BRANDING IRON AT STERLING RANCH FIL. NO. 1 BETWEEN VOLLMER ROAD - DINES BOULEVARD

EMERGENCY ACCESS RD PLANS

OCTOBER 2018

BRANDING IRON AT STERLING RANCH FIL. NO. 1
EMERGENCY ACCESS PLANS
DATE: 10/26/2018
SCALE: HORIZONTAL: N/A VERTICAL: N/A
PROJECT NO. 09-006
DESIGNED BY: DM
DRAWN BY: JWP
CHECKED BY: VAS
SHEET 1 OF 6
S101

**EMERGENCY ACCESS ROAD
(PORTION OF FUTURE MARKSHEFFEL ROAD)**

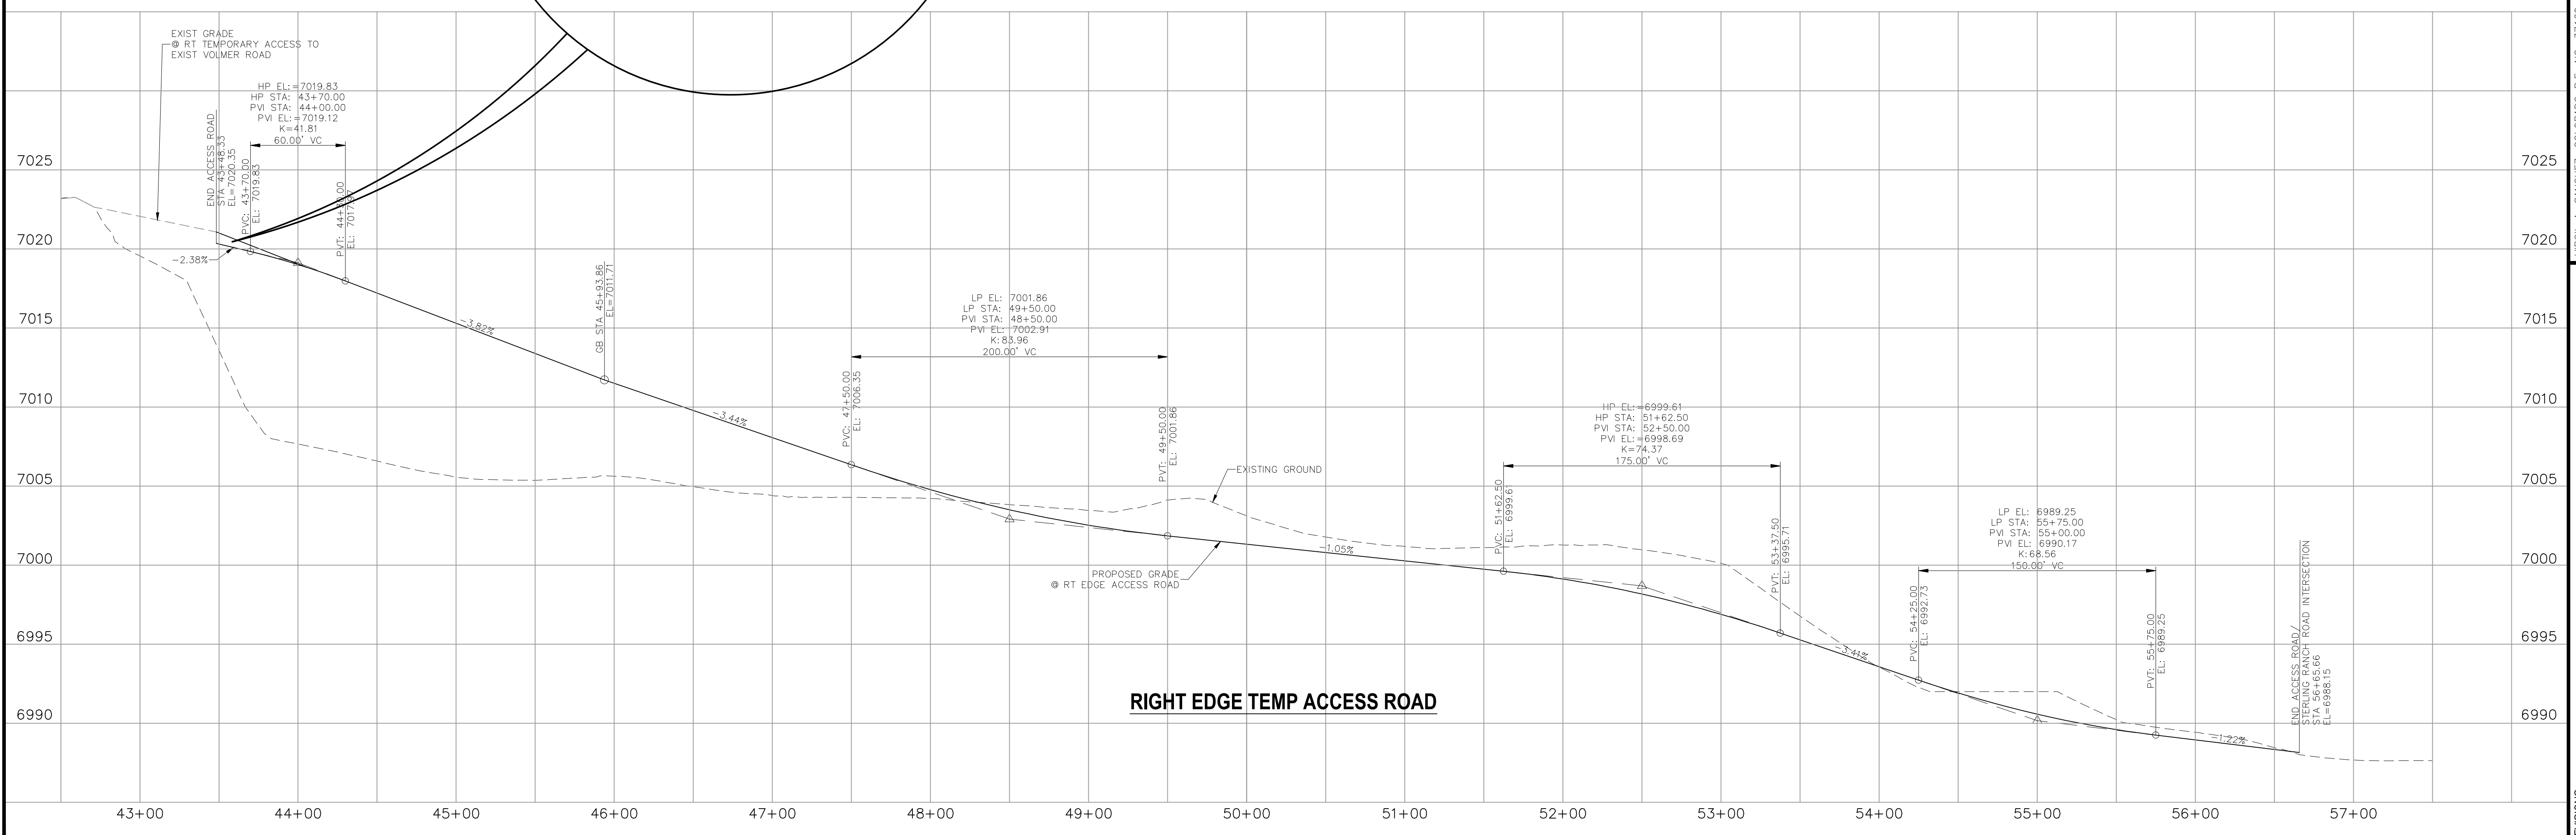
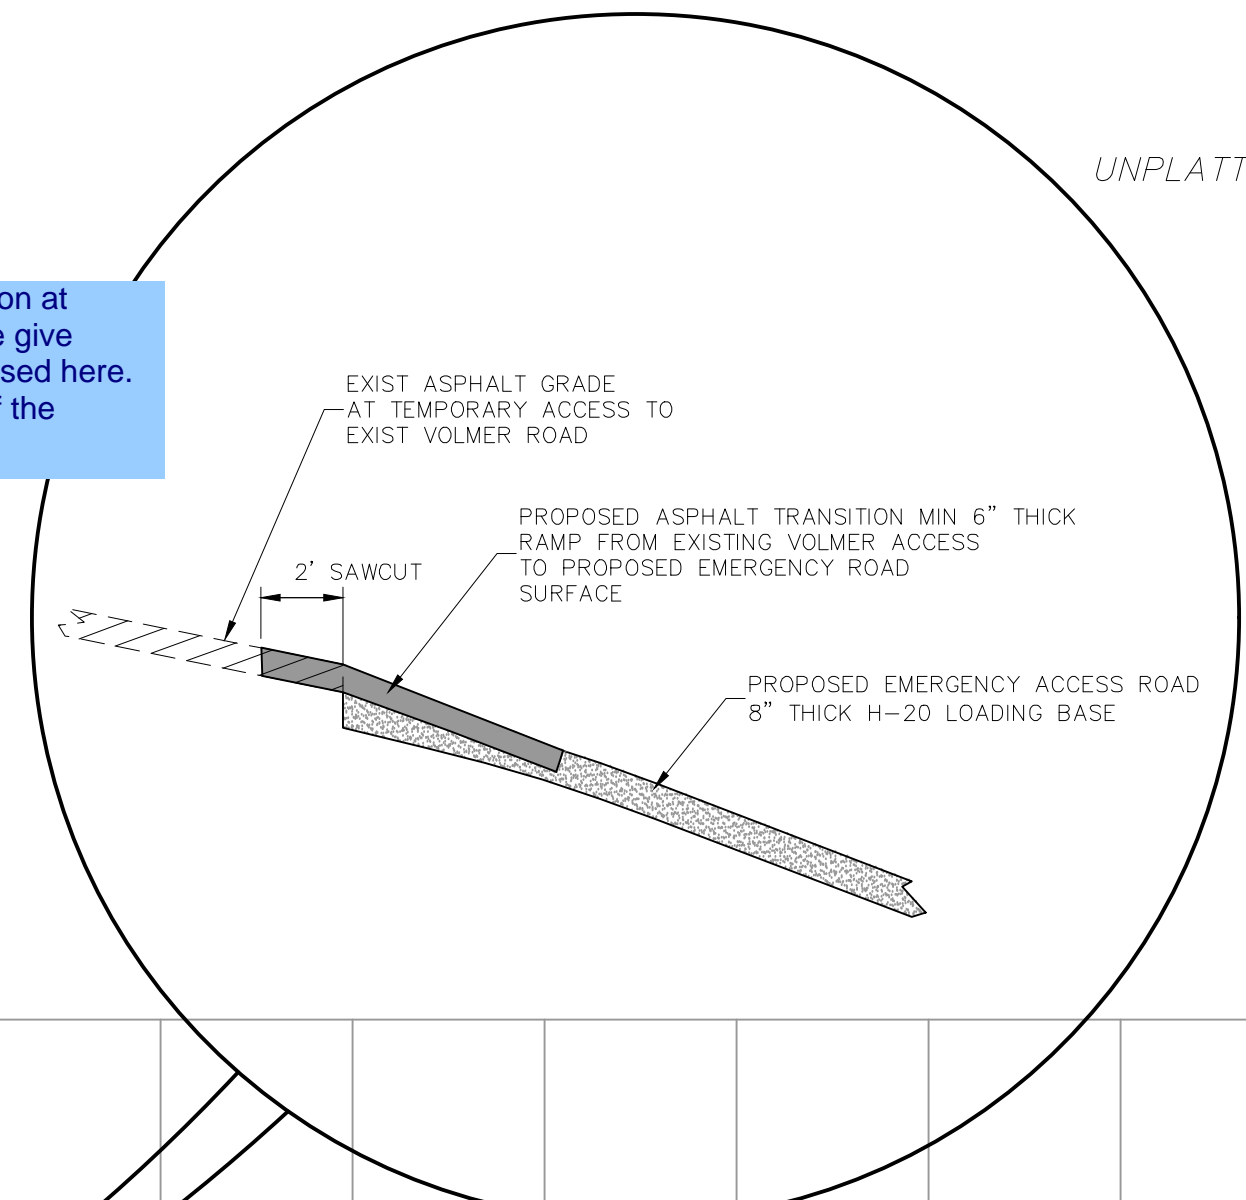
show and label shoulders

sawcut
Asphalt transition needs to be a minimum depth.

EMERGENCY ACCESS ROAD SIGNING PLAN

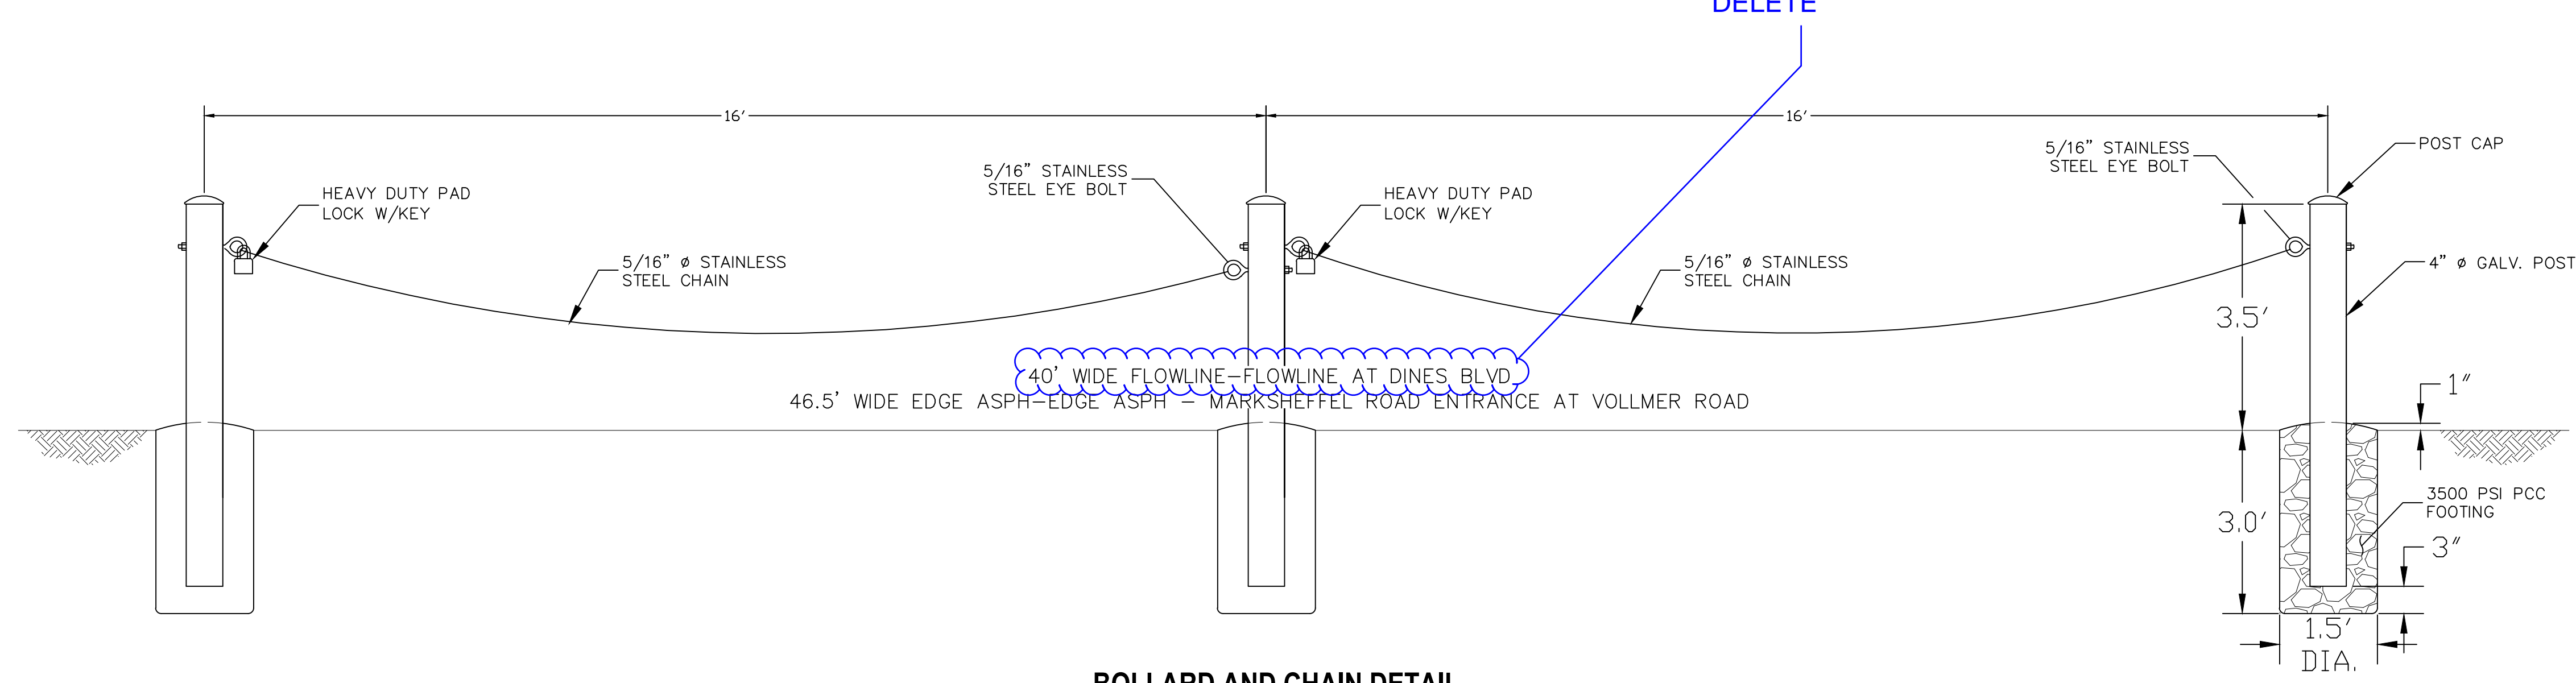
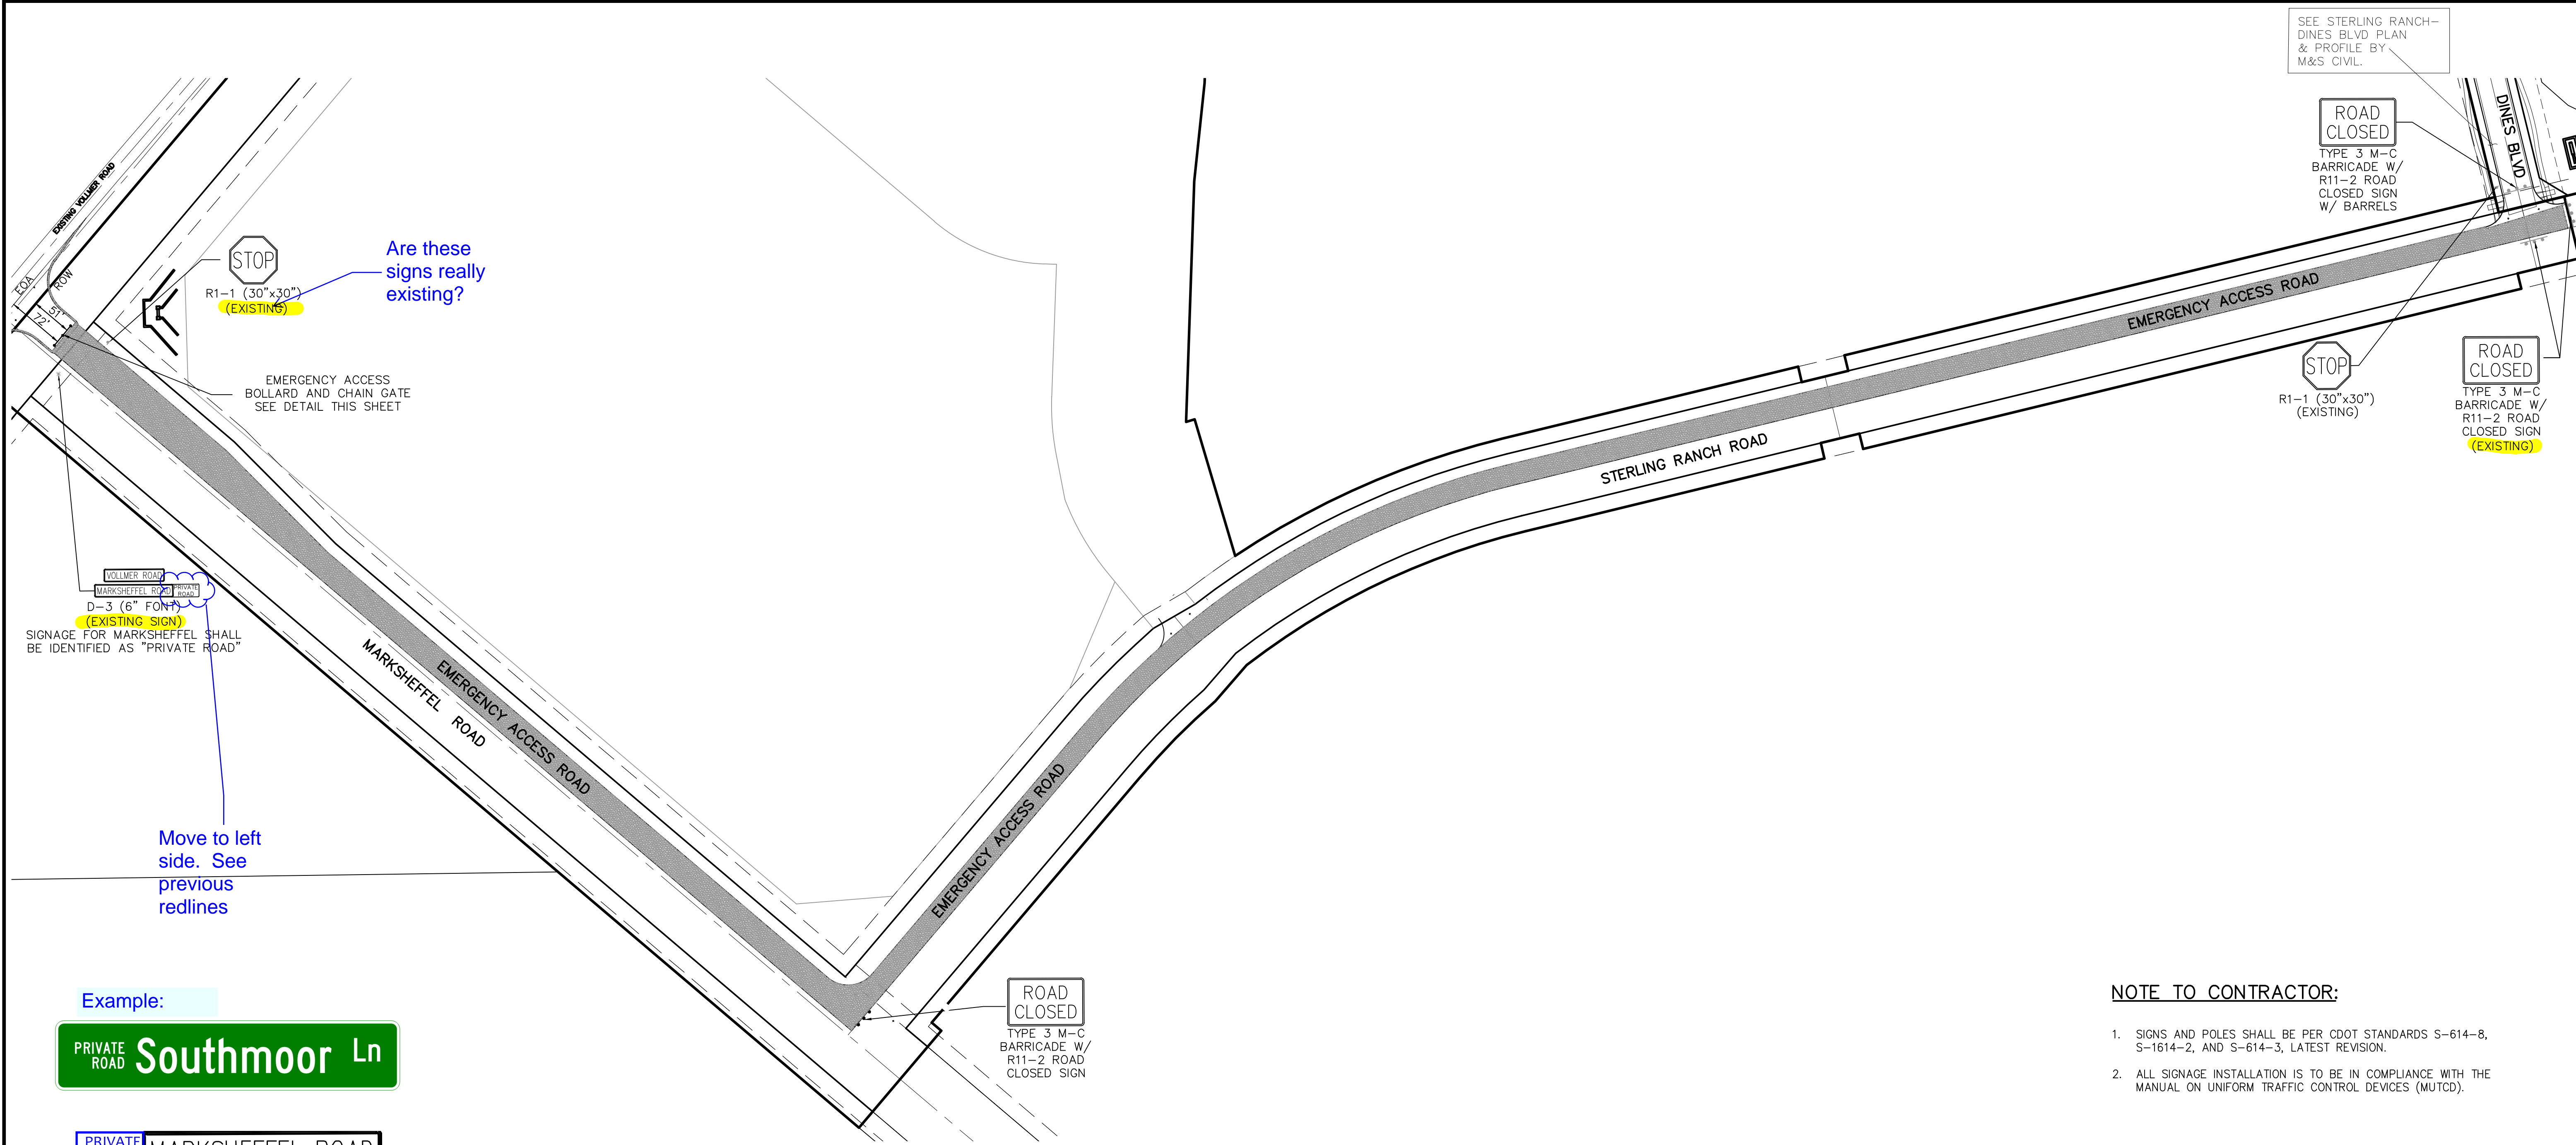
If road name signs will be placed, change Marksheffel to Private Road sign. See Below.
